PLANNING BOARD REPORT PORTLAND, MAINE

Old Barn Estates 16 Lot Subdivision
1062 Ocean Avenue (Ledgewood Drive)

Level III Subdivision Review

Project ID #2012-584

Old Barn Estates
Subdivision Street Extension Sketch
January 28, 2013

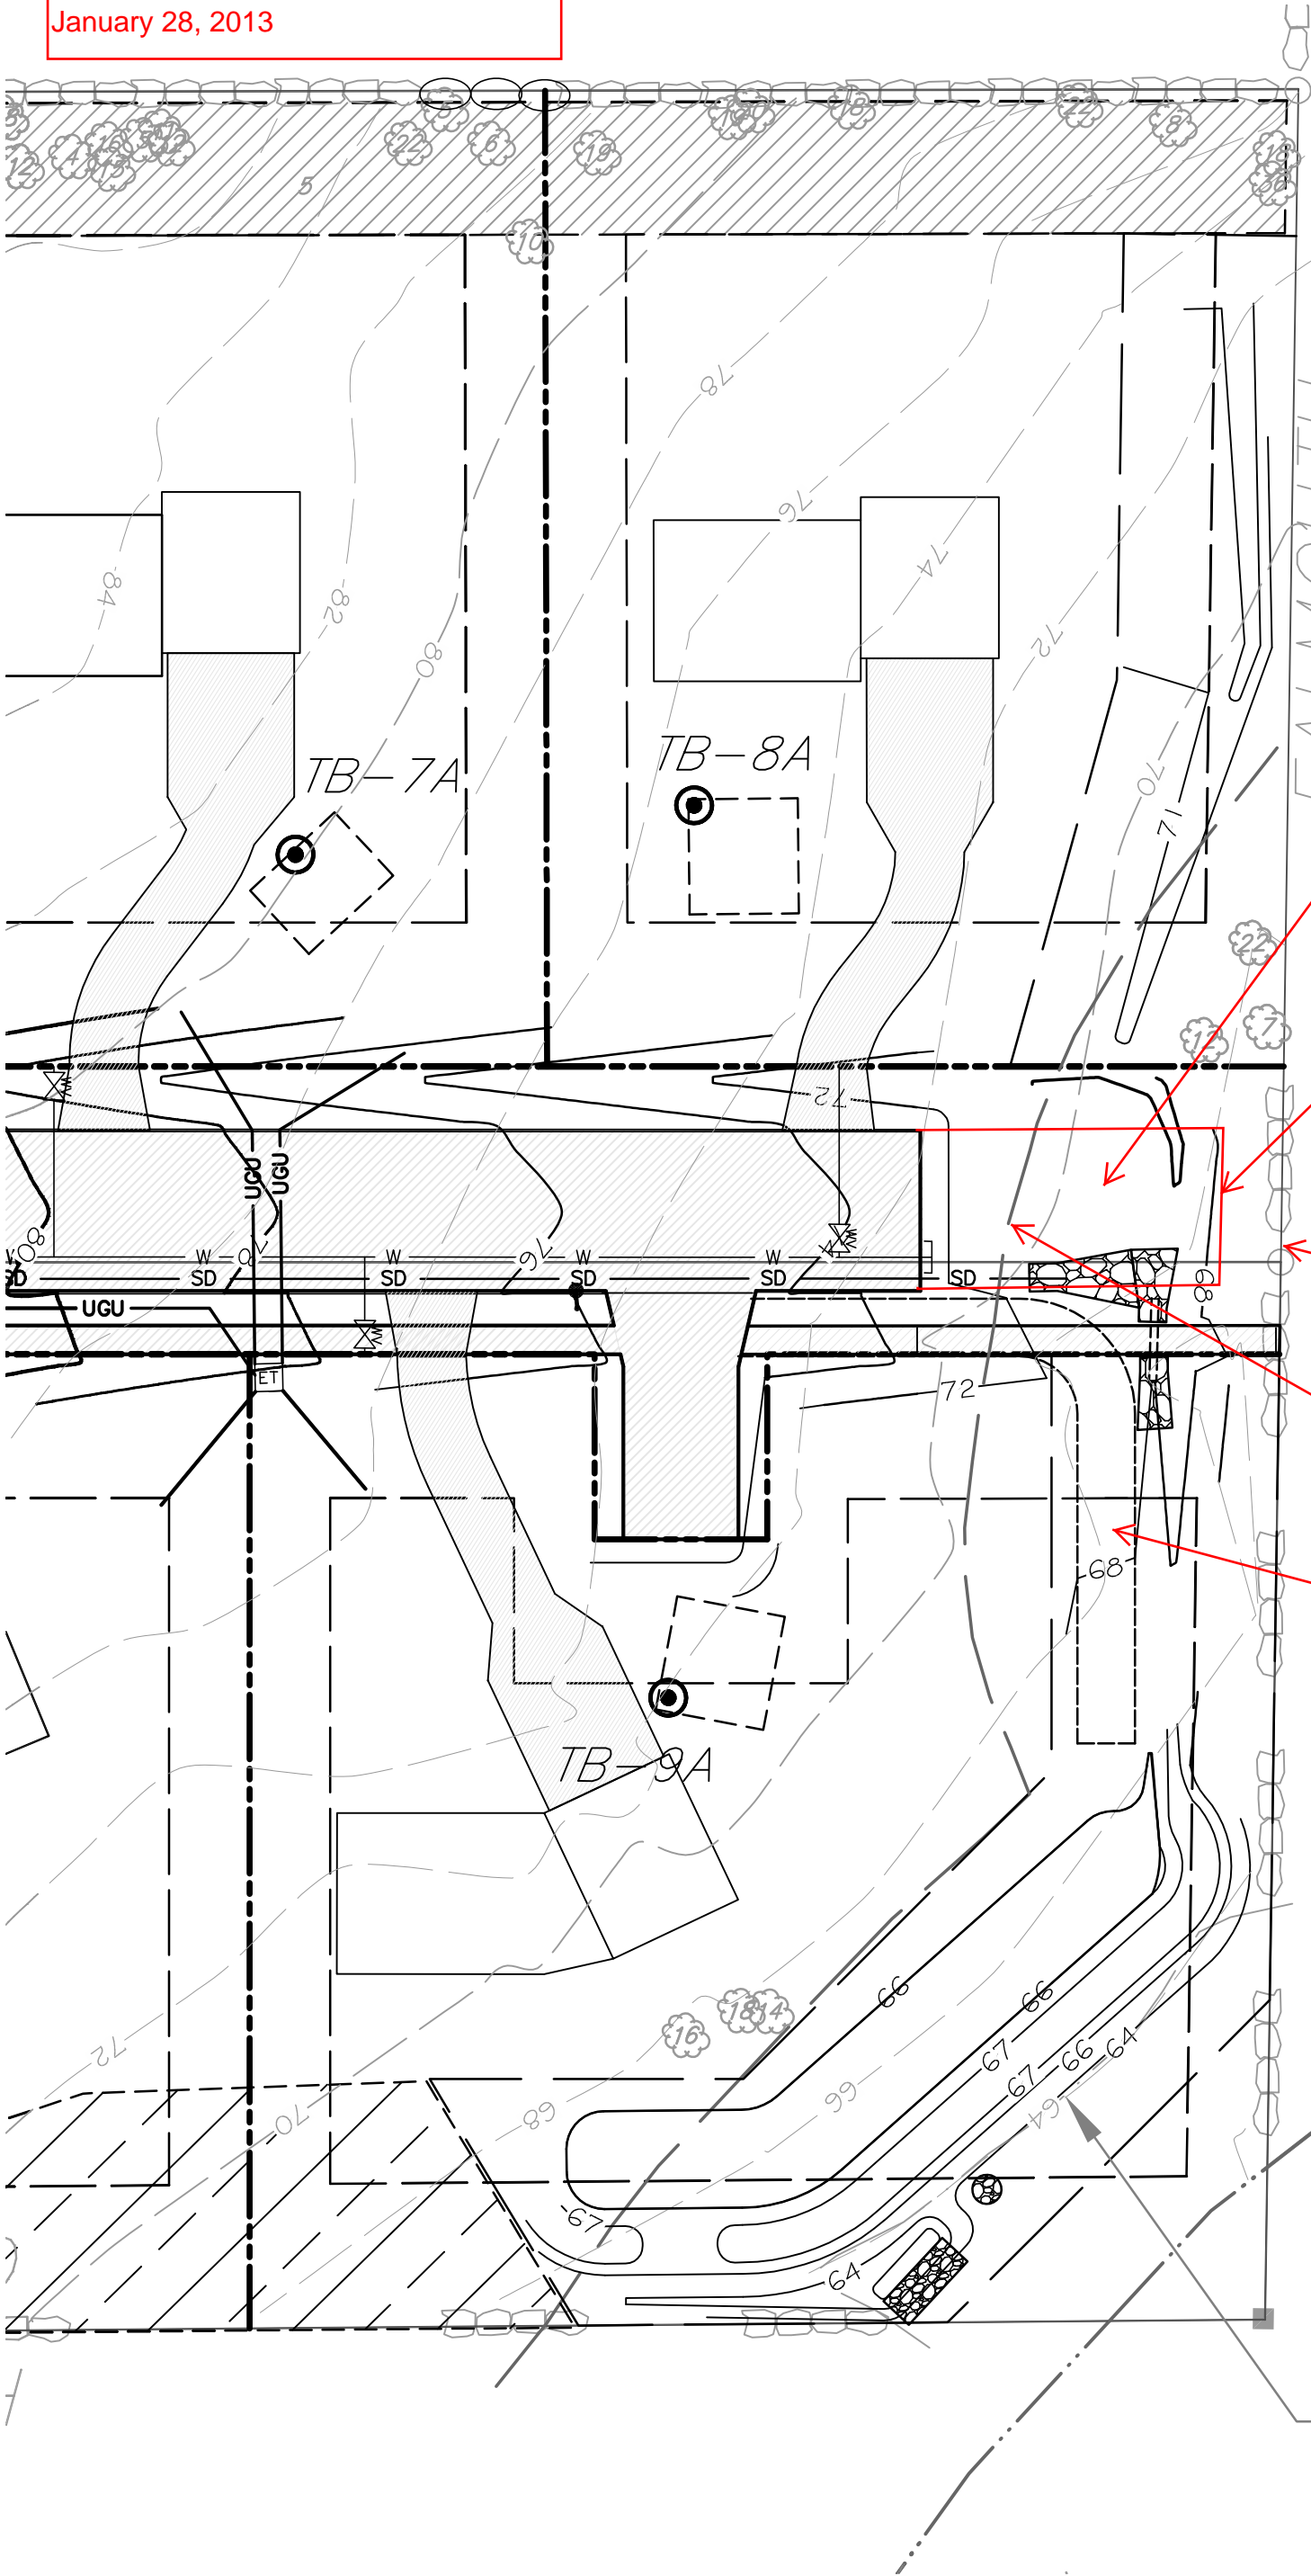
Marge Schmuckal, Zoning Administrator, requested and received further information regarding the flood zone delineation (Att. 1) and also was concerned that *"Ice Pond Road is not meeting the requirements of 14-403 which requires streets to be put in from where ever pavement ends to the end of the lot(s) being developed. Ice Pond Road stops short approximately 65" from the end of both properties lot #8 & lot #9. The proposed City Street needs to be extended to the end of the lots being developed."* (Att. 8)

After discussions with Corporation Counsel, staff determined that in this case it would be possible to end the ROW where the paved street ends and include the land between the ROW and the Falmouth boundary in Lots #8 and 9. A public access easement of 20 feet (with the gravel walkway within this area) would extend from the ROW sidewalk within the site to the off-site trail network within the Falmouth Land Trust area to ensure public access connectivity (see *Connectivity* below for further discussion). This would avoid the 14-403 requirement for the developers of lots #8 and #9 to pave along the entirety of their frontage and encroach into the wetland buffer.
